From: Michael Eastham
Sent: 16 January 2018 12:21
To: Planning.Responses
Subject: FW: BN/28/17/RES - The former Lillies Caravan Park, Barnham

From: Paul Cann
Sent: 16 January 2018 11:41
To: 'John Freeman'
Cc: [REDACTED]
Subject: RE: BN/28/17/RES - The former Lillies Caravan Park, Barnham

From: Thomas Callaway
Sent: 16 September 2015 15:55
To: Planning.Responses
Subject: RE: Planning Consultation on: BN/32/15/OUT

APPENDIX D

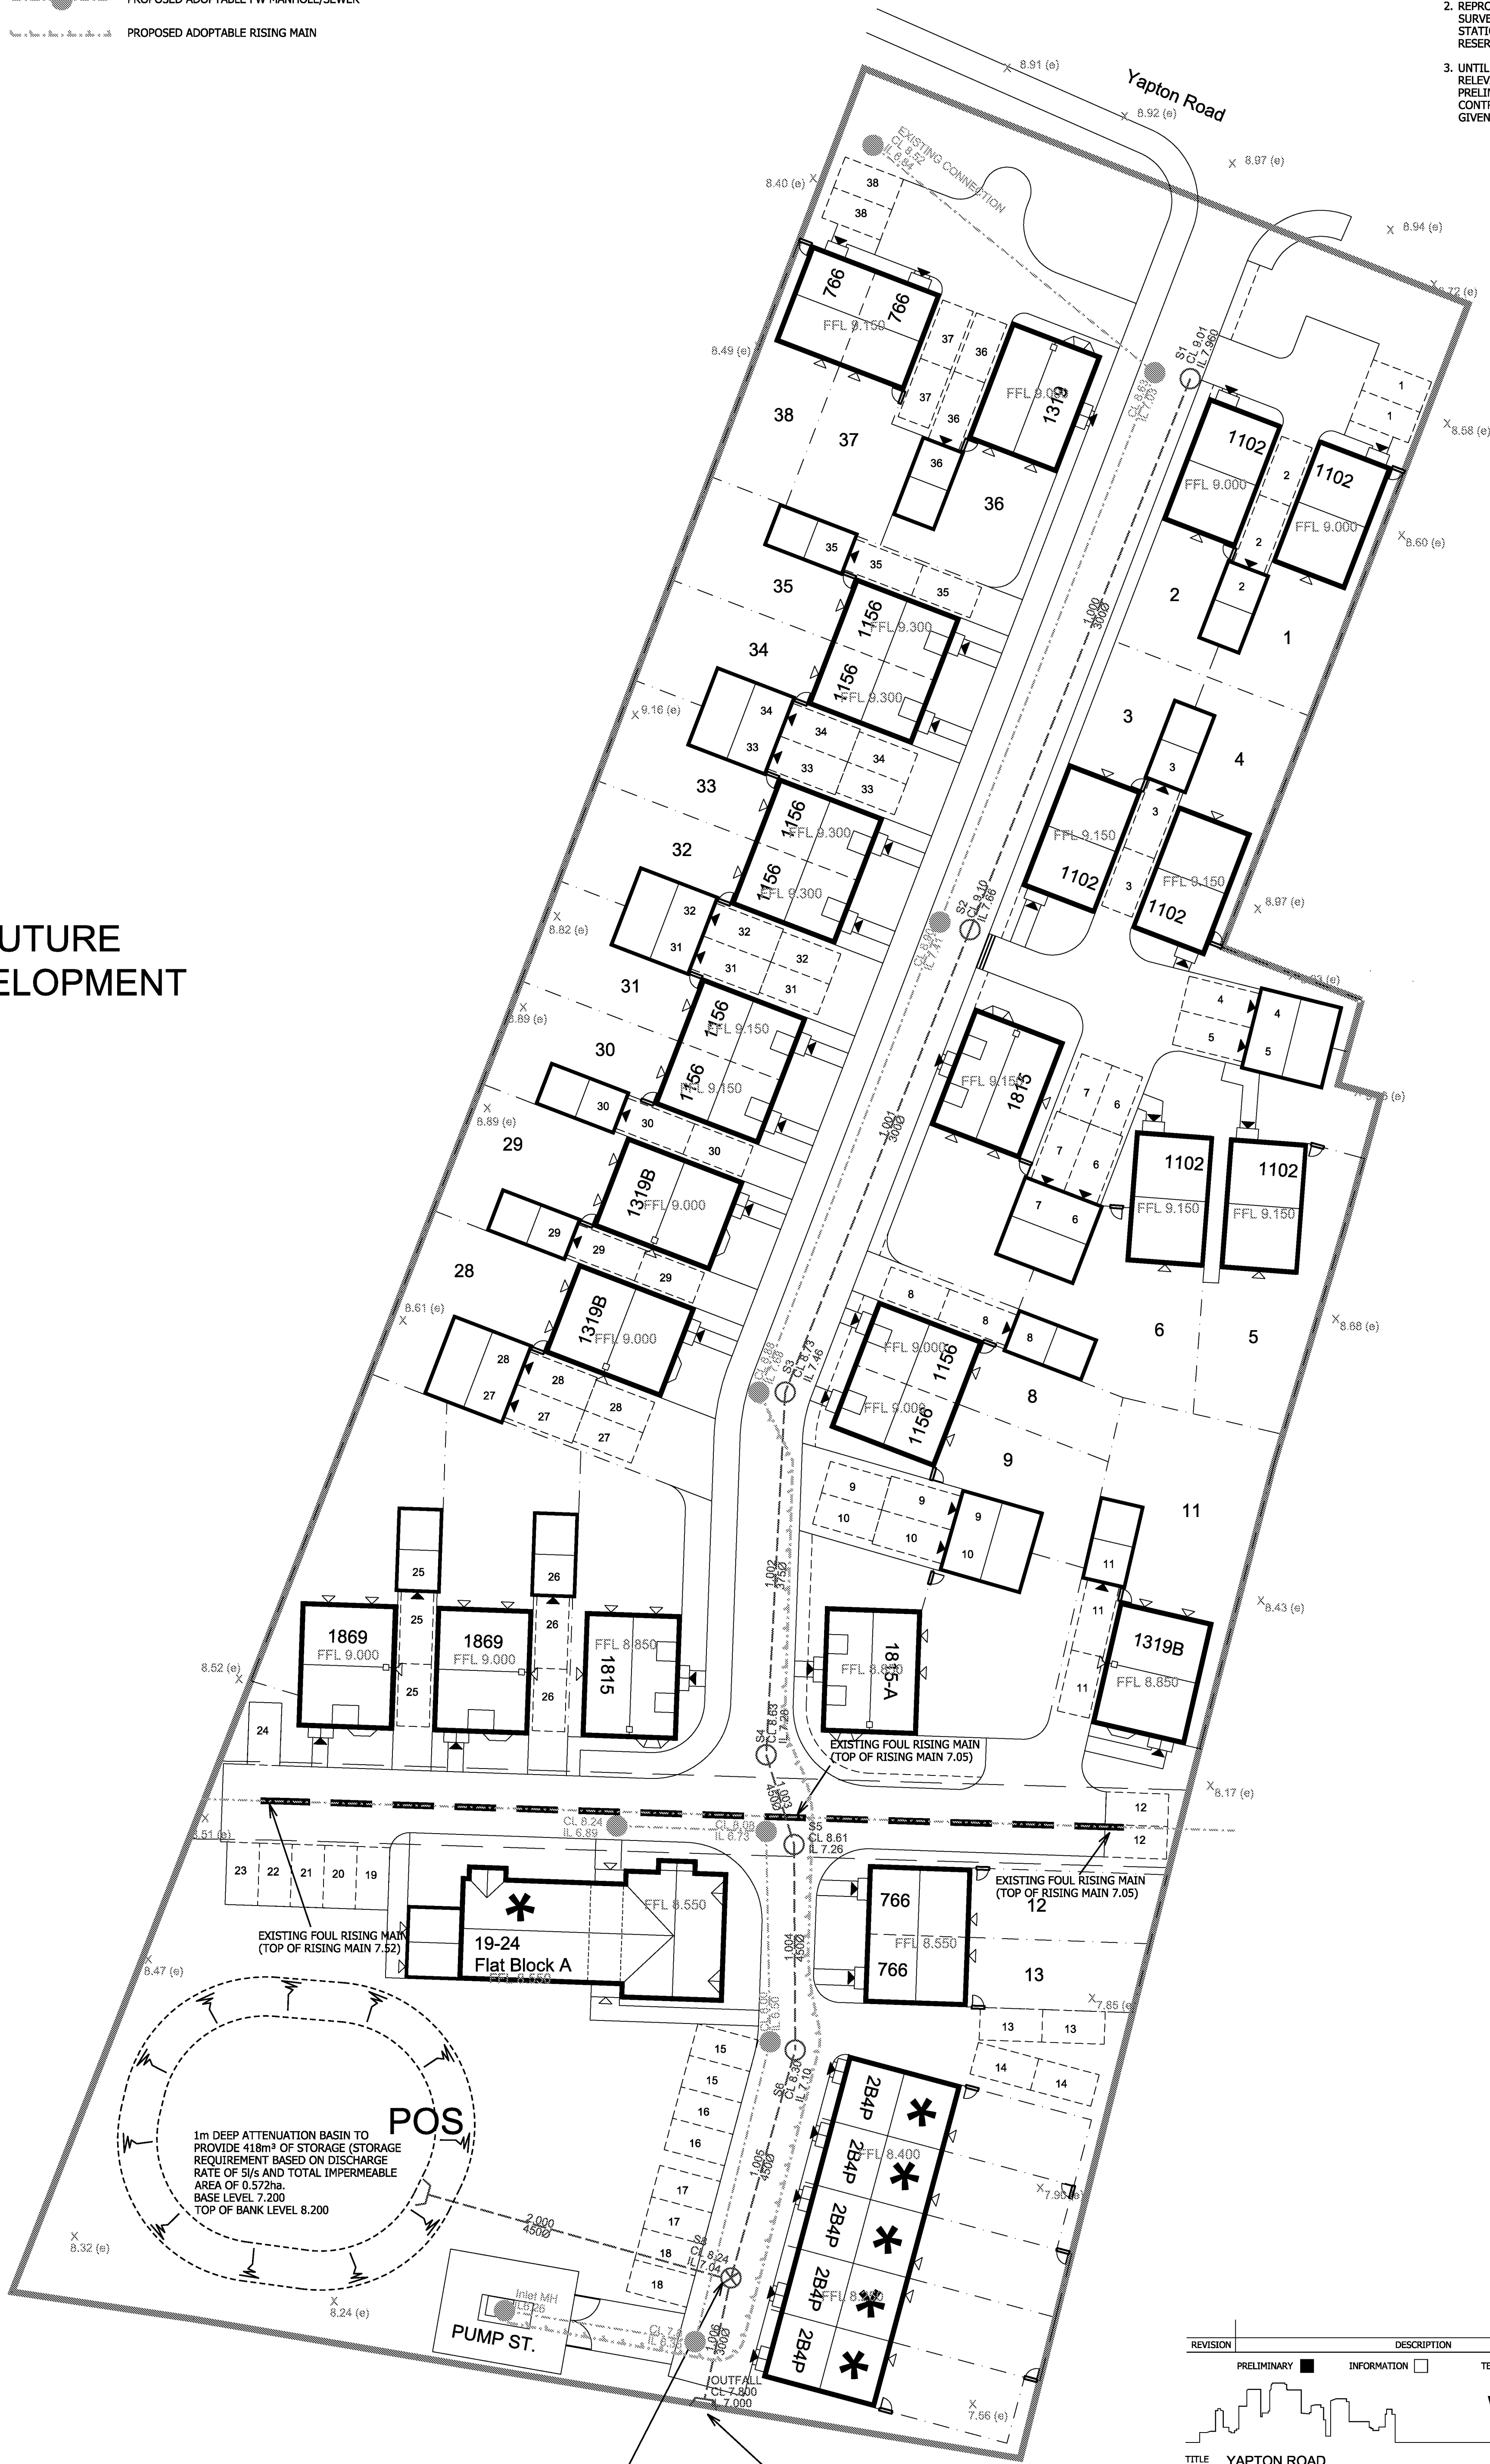
The 'detailed' drainage design would be dealt with under a 'Discharge of condition' application, however, the proposed drainage drawing provided to date has been lacking in terms of suds features to provide adequate water treatment, etc. You will note on application BN/32/15/OUT, we made comments mentioning the use of permeable surface driveways (see enclosed). Whilst infiltration has now been ruled out, there is no reason why tanked permeable driveways cannot be incorporated. These structures would provide attenuation and water treatment. The risk of pollution is highest from vehicles standing on driveways, due to oil leaks, etc.

The pond itself will provide minimal water treatment as it is offline, and normal flows will not pass through it. Therefore, at this stage we are looking for a slightly more detailed drainage layout incorporating measures to provide water treatment in order to reduce the pollution risk. Further detail can be dealt with at DOC stage.

By incorporating, the permeable paving, you may also be able to reduce the size of the pond (subject to calculation). If you wanted to go a step further and use permeable roads, then again treatment would be greatly improved and offer the potential of further reductions in the size of the pond.

To date, I have not seen any proposals to incorporate other suds storage features in the development ie. tanked permeable paving. This could reduce the size/depth of pond required, as additional water storage will be provided.

We did make it clear to them that we wanted to see other suds features on the development to help provide further water treatment, etc. This is now particularly important as the pond will be 'offline' ie. normal flows will not pass through the pond, and water treatment will therefore be limited based upon their current scheme.

Please note that the pond will also need to be tanked/lined to ensure that it does not fill with groundwater (high water table here).

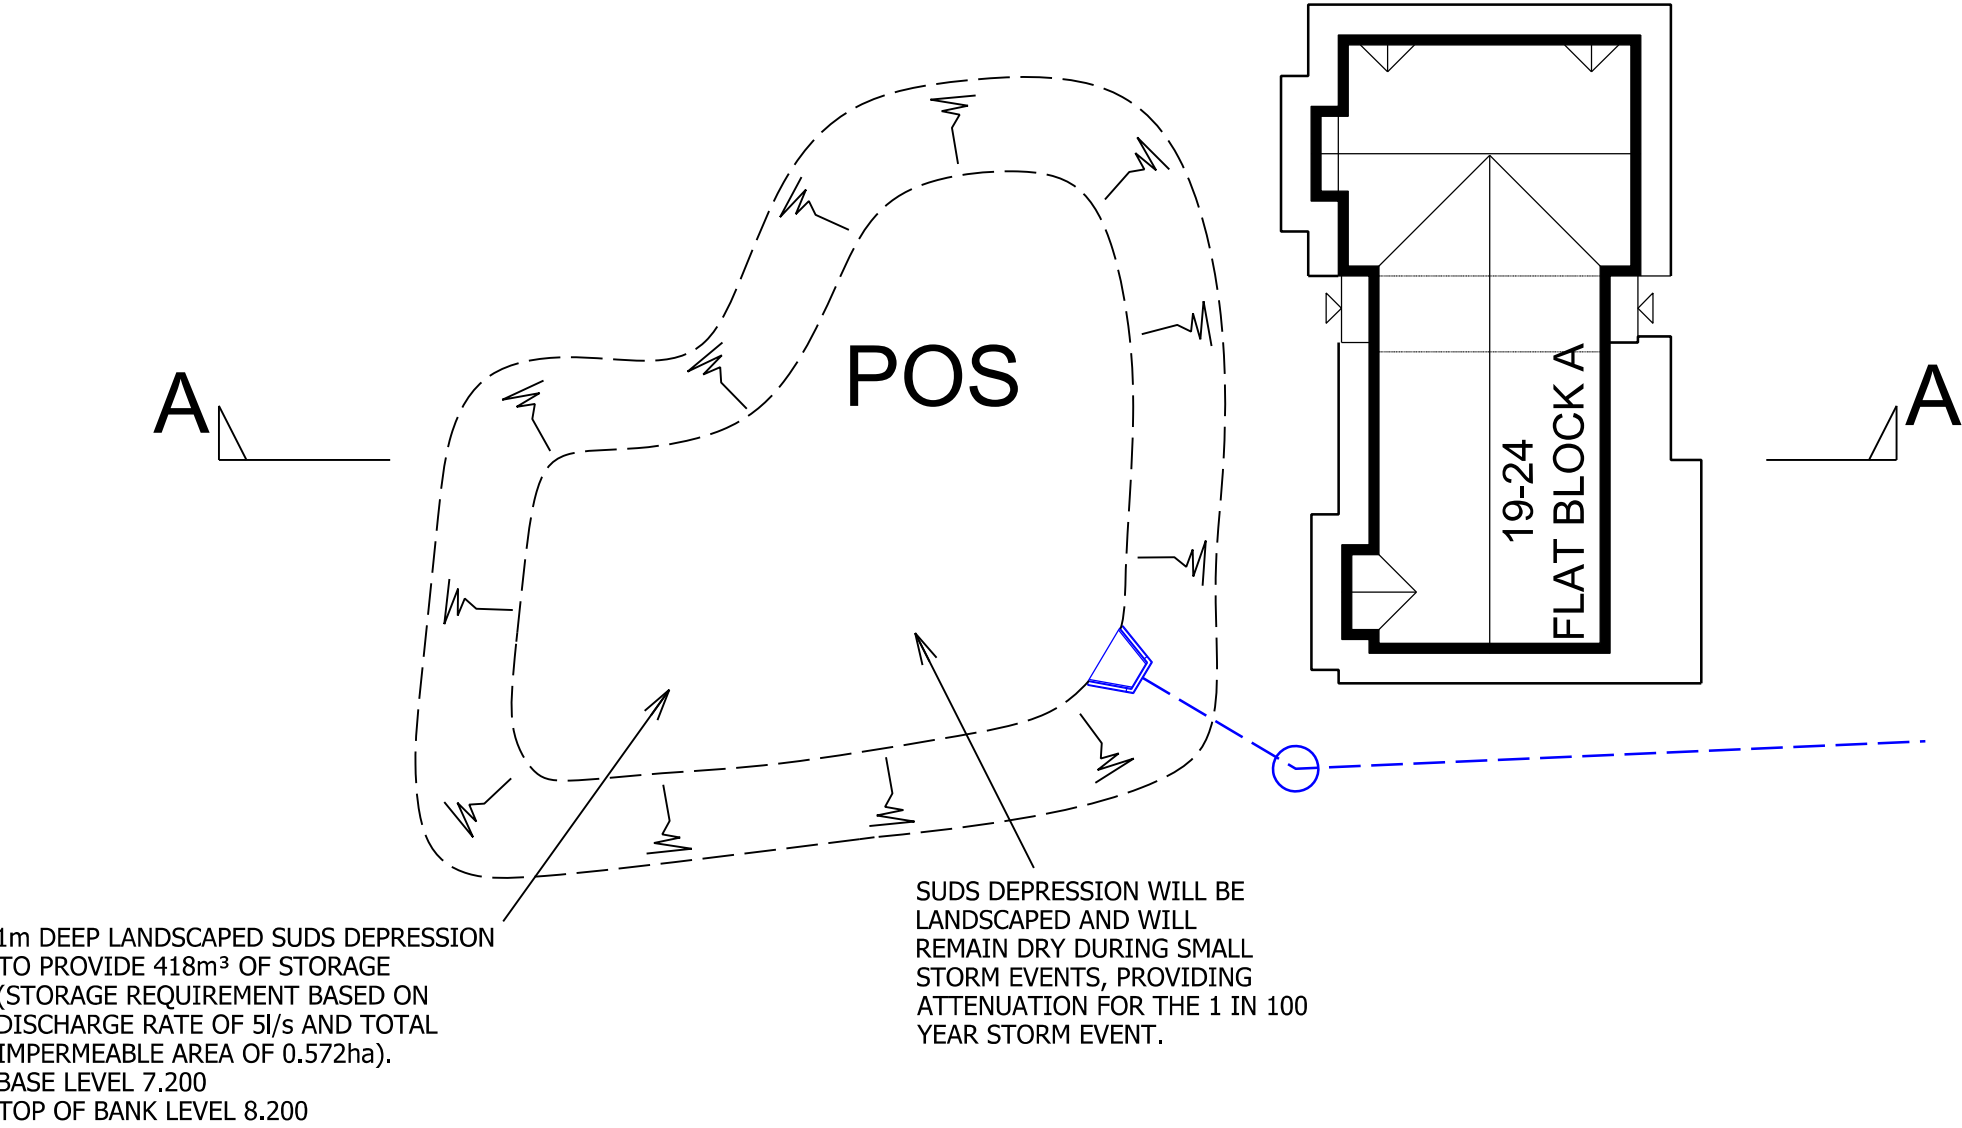
- I still remain to be convinced that a basin with a 1.0m depression taking the majority of the POS provides safe and useable POS? I would recommend that now that this detail has been supplied that it is run past our Drainage Engineers for their view on the 1 in 100 year storm event scenario and whether they concur that this area would otherwise remain dry in reality? I now refer this to them for an expert opinion.

- I note that the proposer has suggested '**Attenuation basin shape revised and relocated to south western corner**' please can you request a copy of cross section through this area so that the basin shape in relation to the repositioned apartment block can be viewed as proposed build?
- Please can they also confirm where the play offer is to be sited in relation to the open space on the site?
